The Planning Inspectorate
Yr Arolygiaeth Gynllunio

Acceptance of Applications Checklist

A12 Chelmsford to A120 Widening Scheme

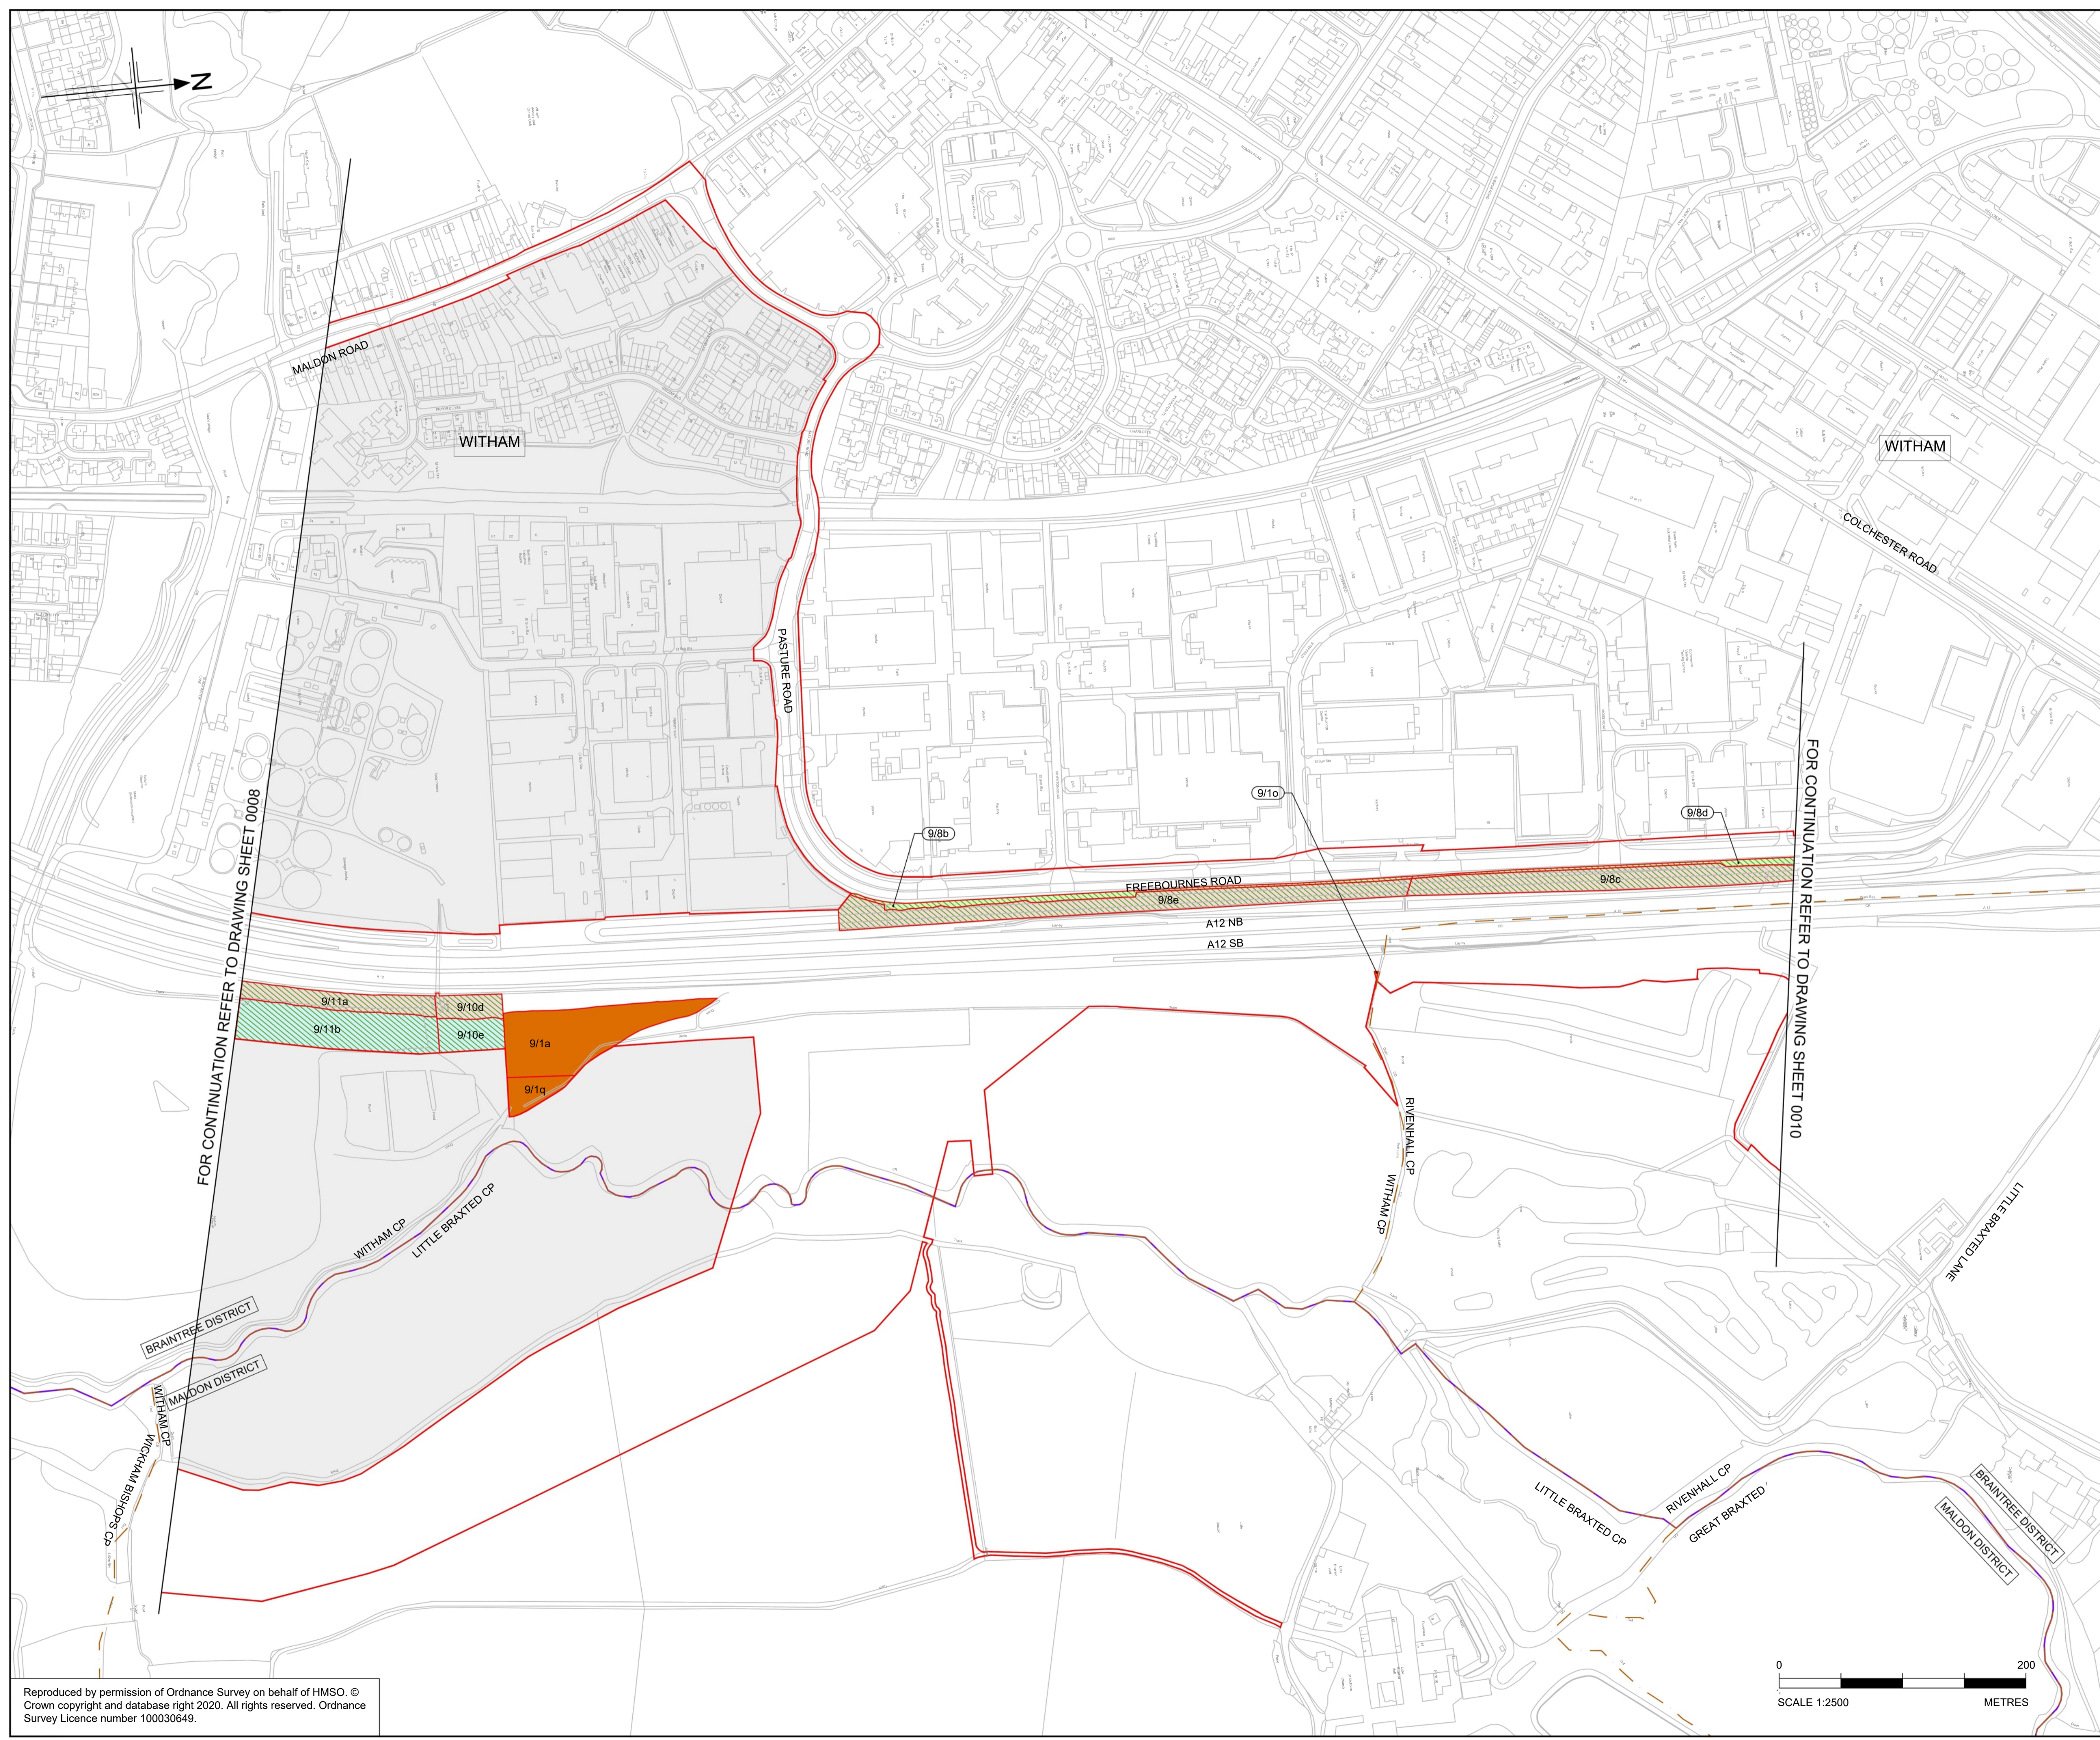
There appears to be unnumbered plots within the **Land Plans (Doc Ref 2.7)**. An example of this can be found on sheet 6. The location is below plot 6/23a, to the right of plot 6/1e and to the left of plot 6/2d.

Section 51 advice has been issued to the Applicant in respect of the above matters:

<http://infrastructure.planninginspectorate.gov.uk/document/TR010060-000431>
